PLANNING CONSULTATION RESPONSE

Application No	2025 0908
Proposal	Re-engineering and Restoration of Yew Tree Quarry through the importation of non hazardous Excavated Soil Materials
Address	Stairfoot Brickworks, Wombwell Lane, Stairfoot, Barnsley, S70 3NS
Date of Consultation Reply	02/12/2025
Consultee	PROW – S Ford

Figure NTS3

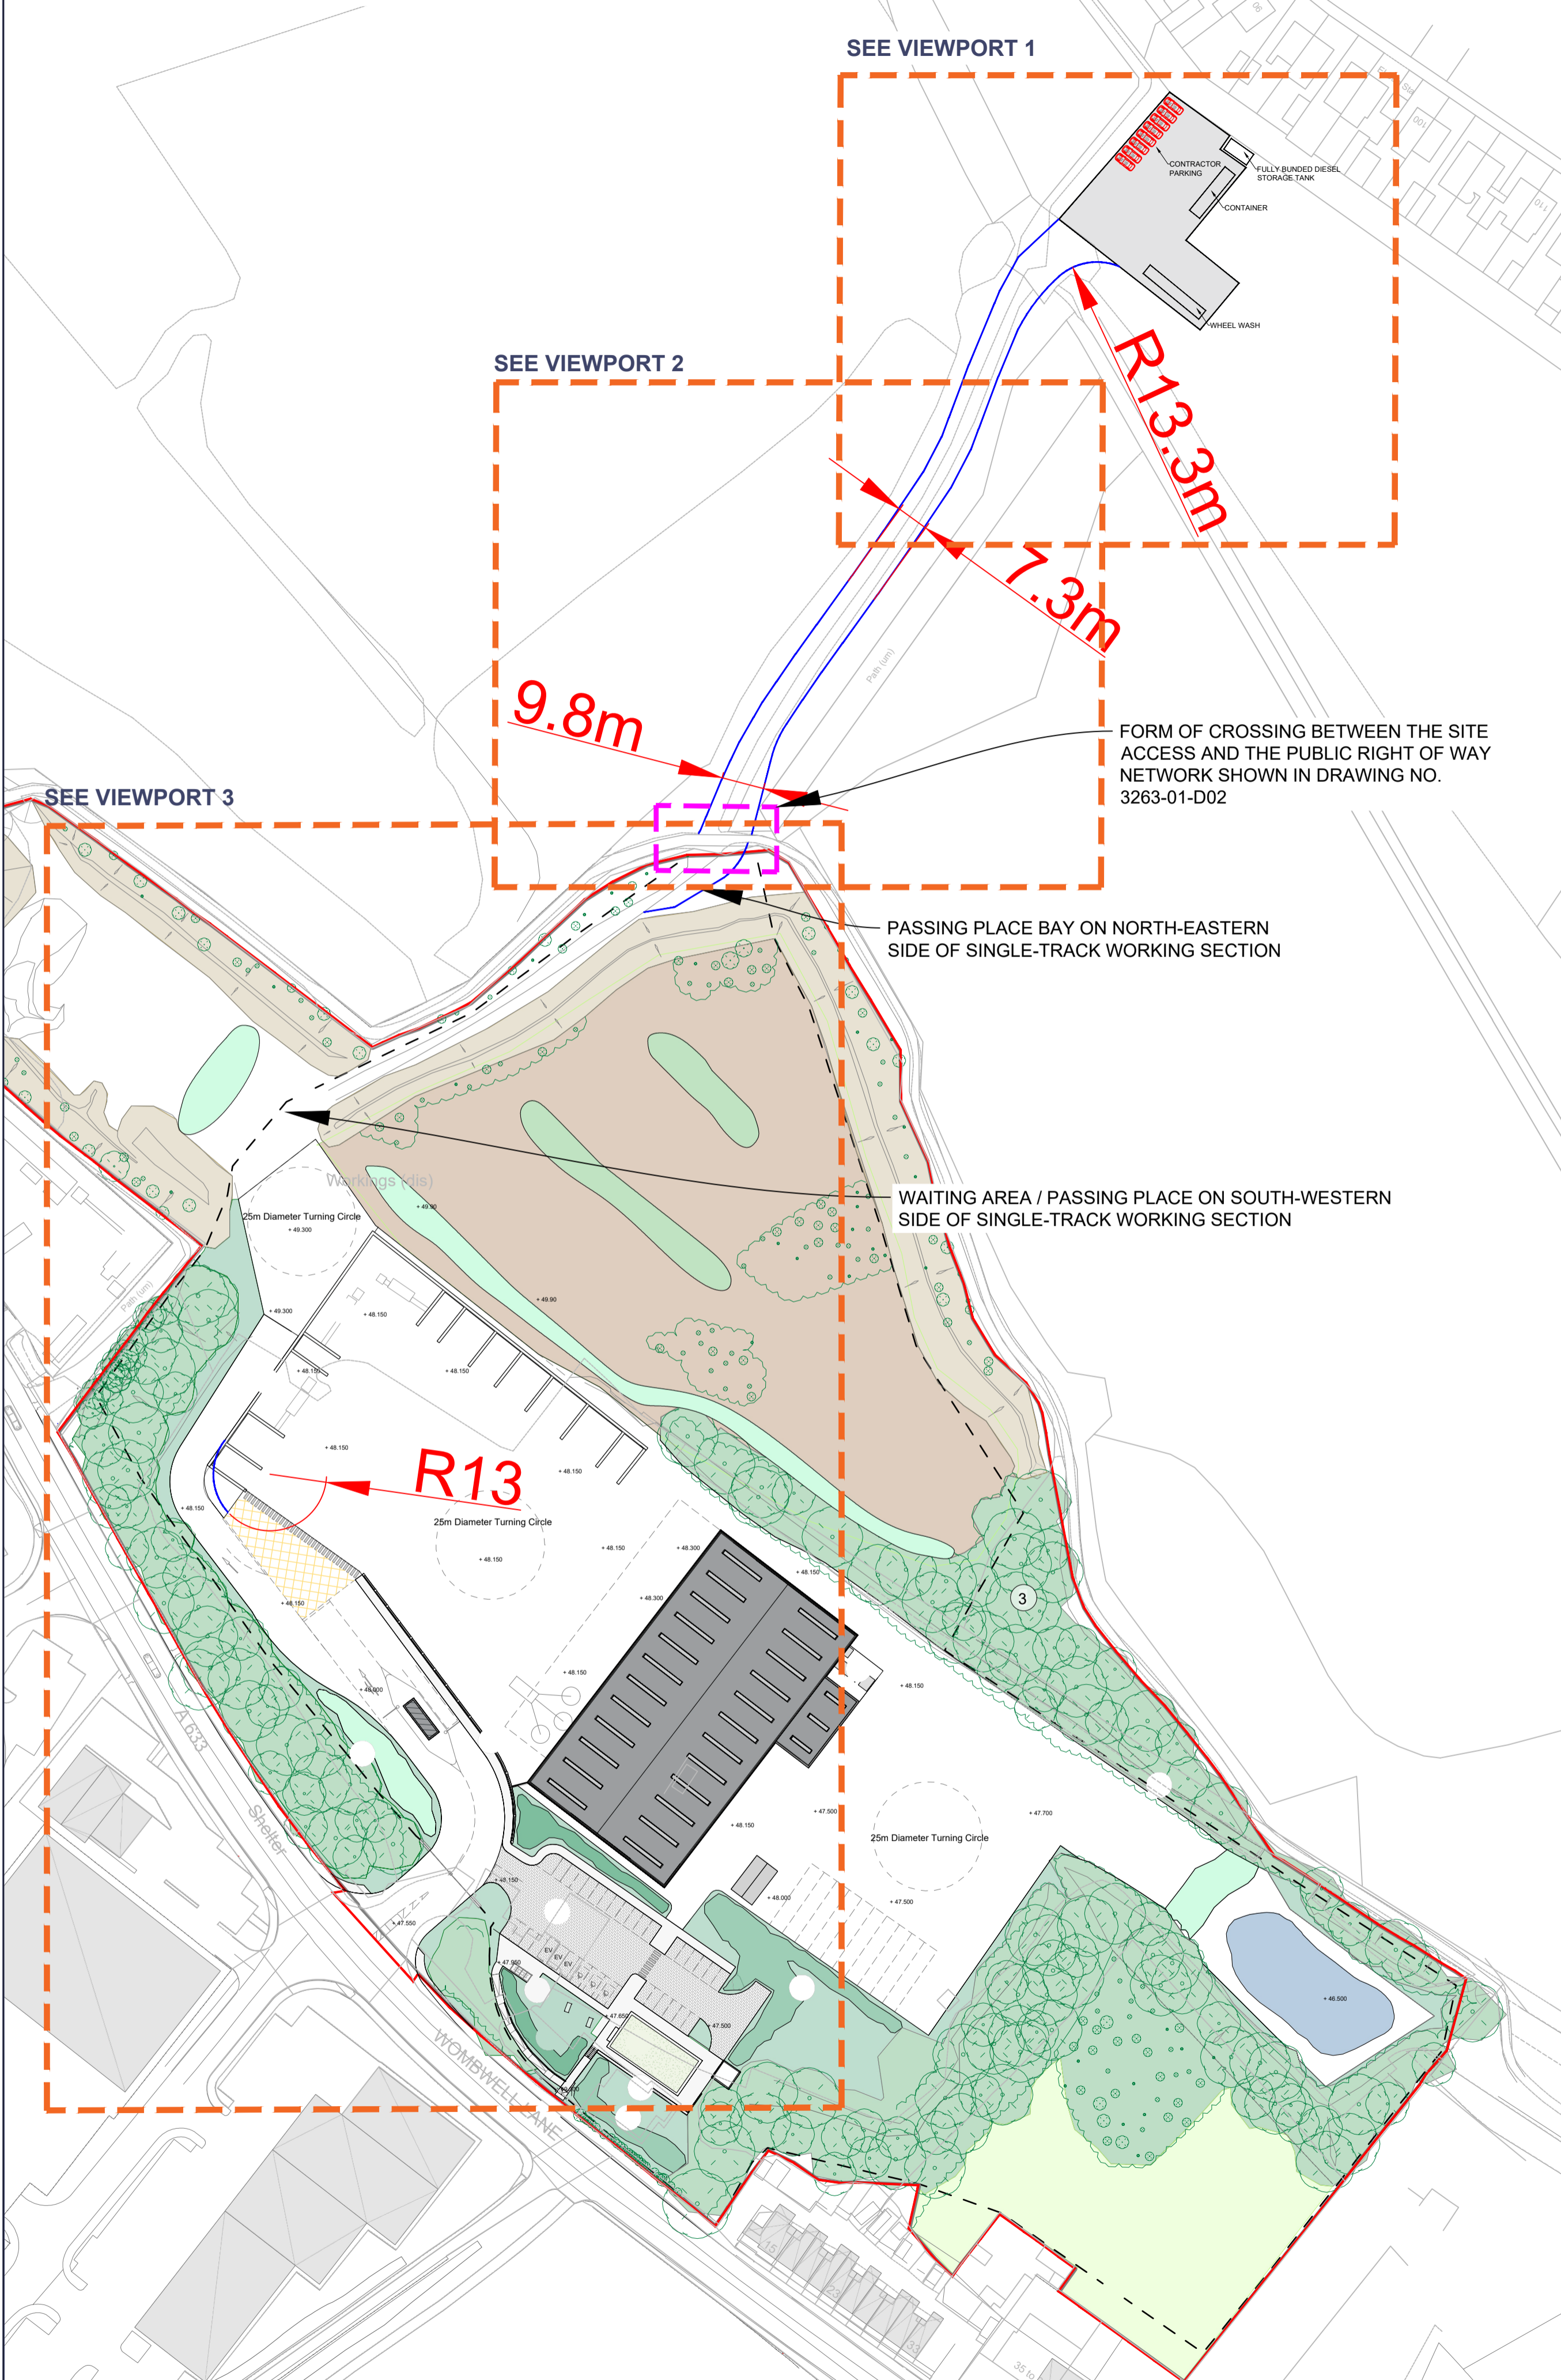
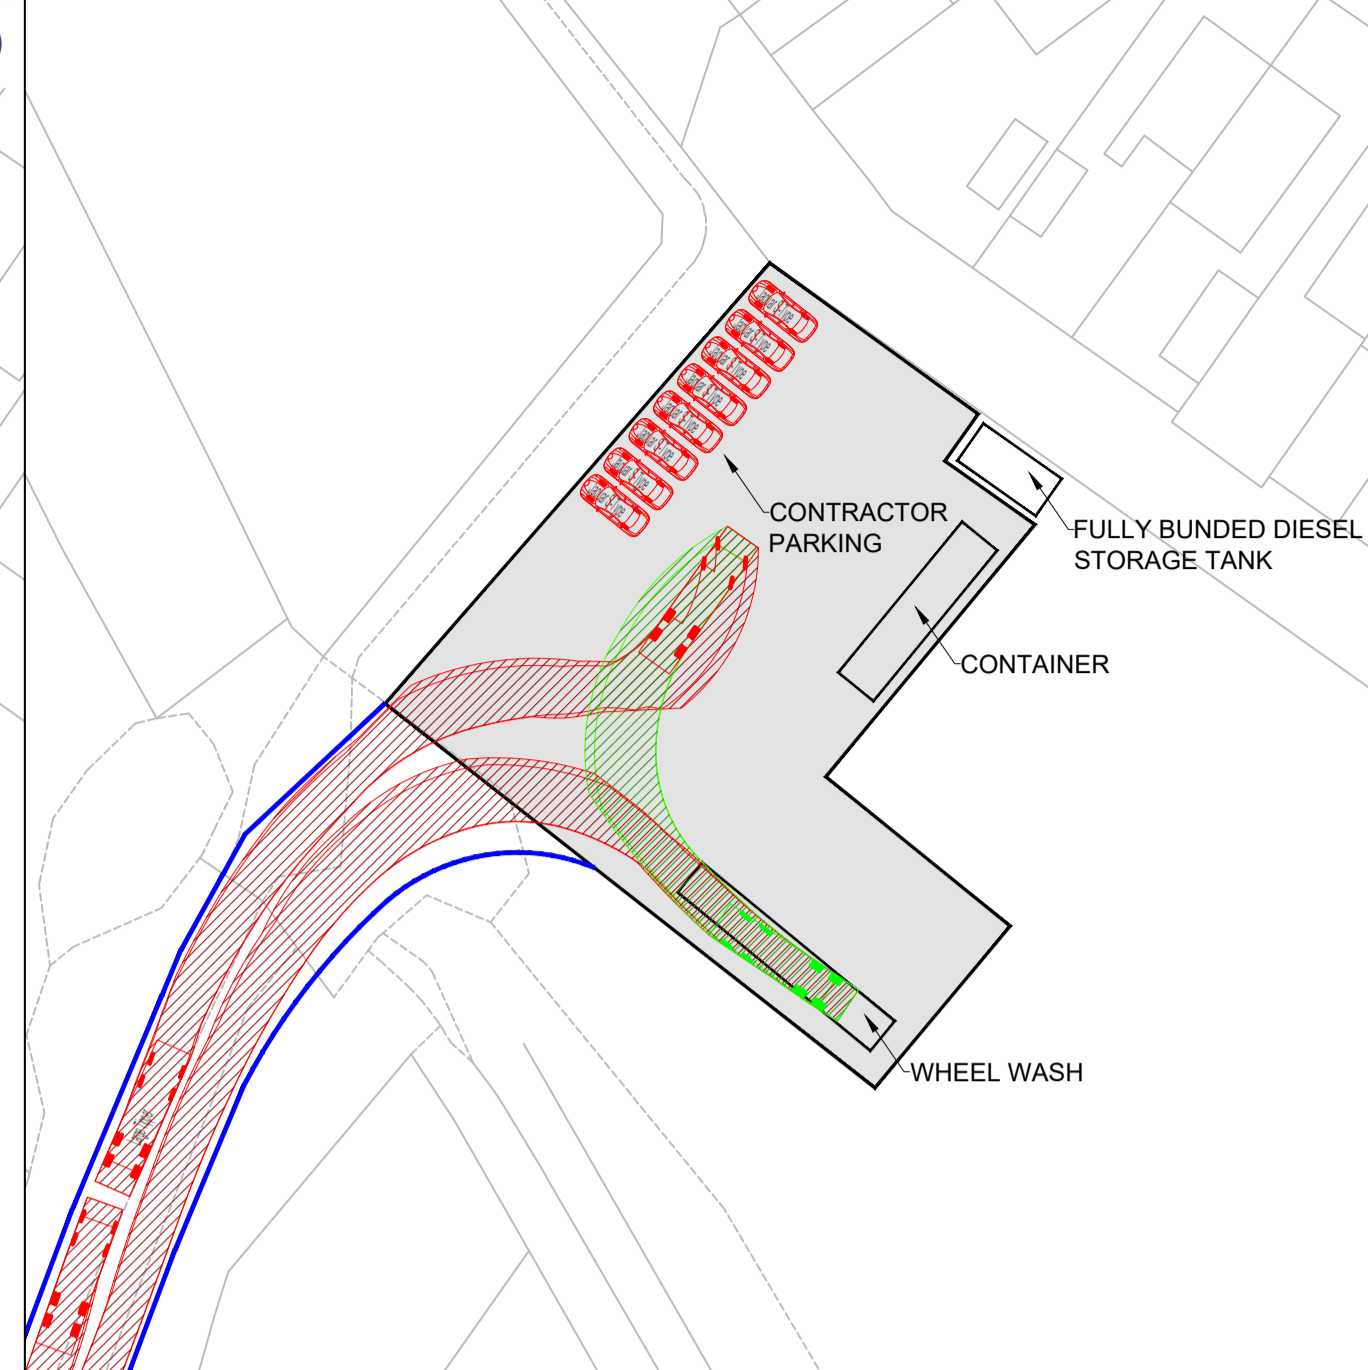
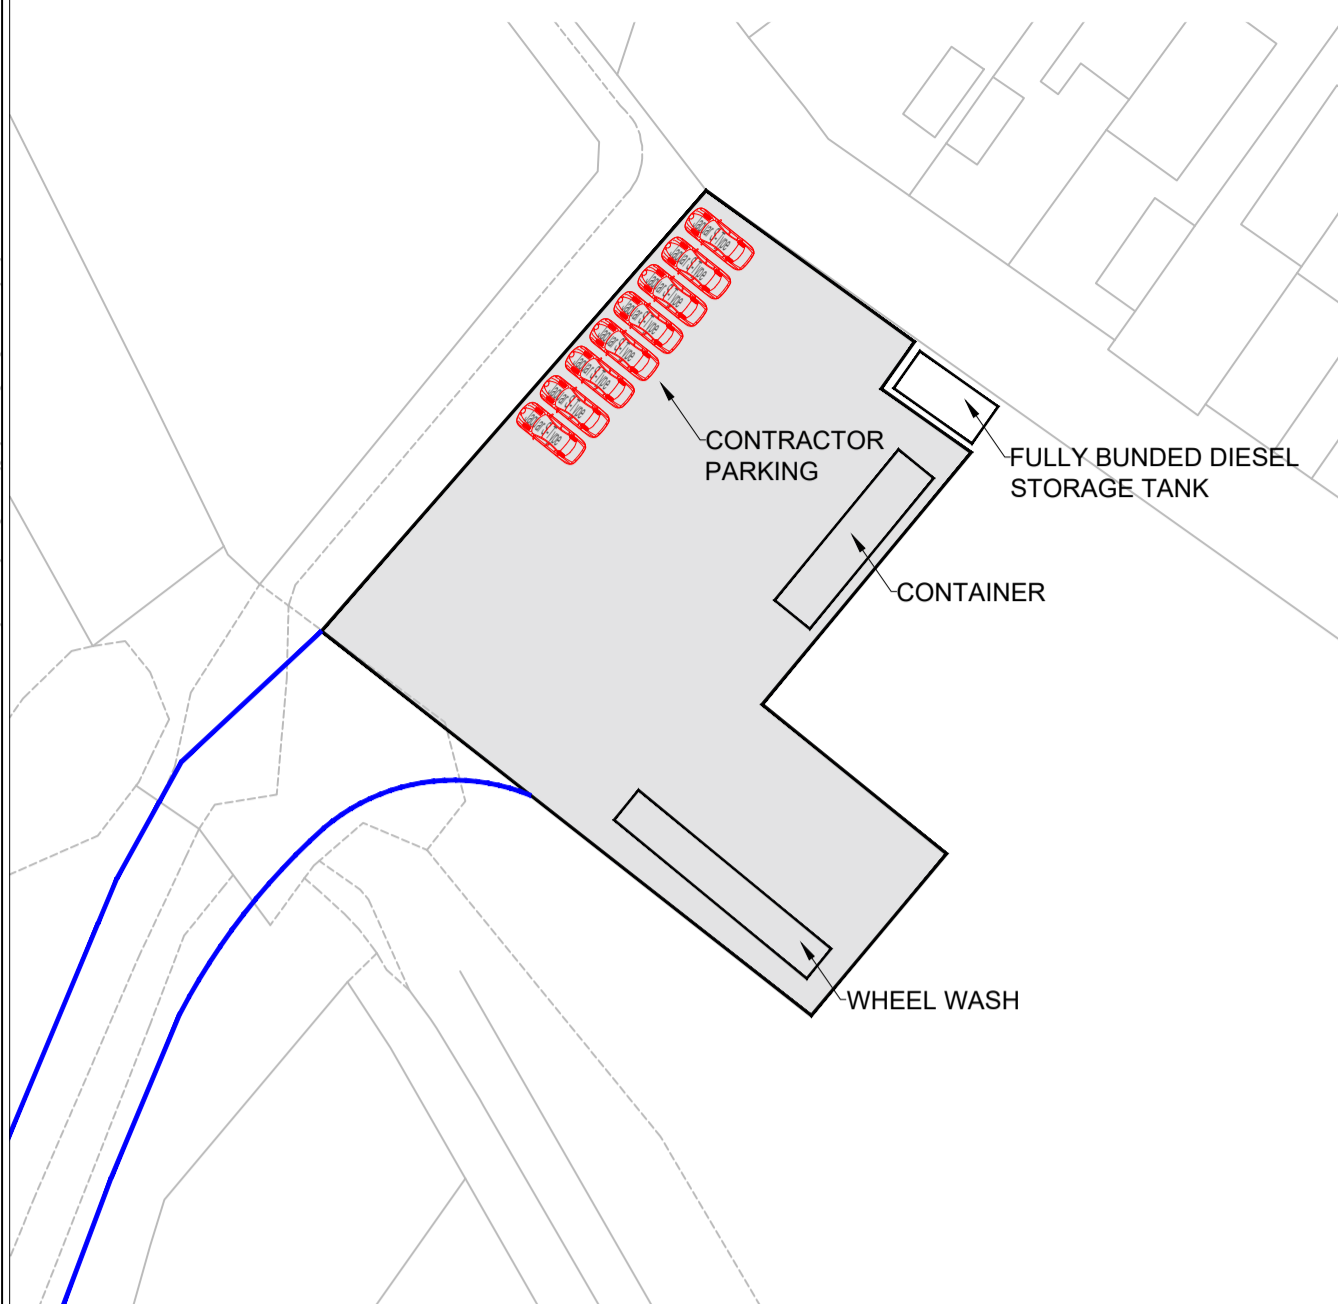
[Figure 3.4 proposed site access arrangements](#) refers to a more detailed plan of the TPT/Access Road crossing as being 3263-01-D02 but unable to find that on the planning file. There are 3 copies of the same footpath diversion plan under different titles!

PRIORITY MUST BE GIVEN TO TPT BRIDLEWAY USERS IN TERMS OF GATES.

Vehicles will need to wait for a banksperson to open the gates (which would then be across the TPT) to allow vehicles to go through along the access road and reopening the crossing to TPT users as soon as it has passed.

The developer must also ensure that at the end of the working day/ when there is no banksman, the gates are prioritising TPT users or it risks accidents and incidents for which it will be liable

Having the gates the other way round risks trapping lots of TPT users on both sides of the crossing point with horses that then could be spooked by vehicles or just the noise and injure themselves of other users.

As well as priority for gates at the crossing, there needs to be plenty of warning signs in both directions that users might come across closed gates to allow vehicles through and what to do.

No works shall start until the TPT and vehicle crossing point issues have been agreed. Priority must be given to the TPT crossing over the vehicle access road, during any vehicle movement periods a banksperson must be in place at the crossing and overnight/weekends the TPT must be open and available to use
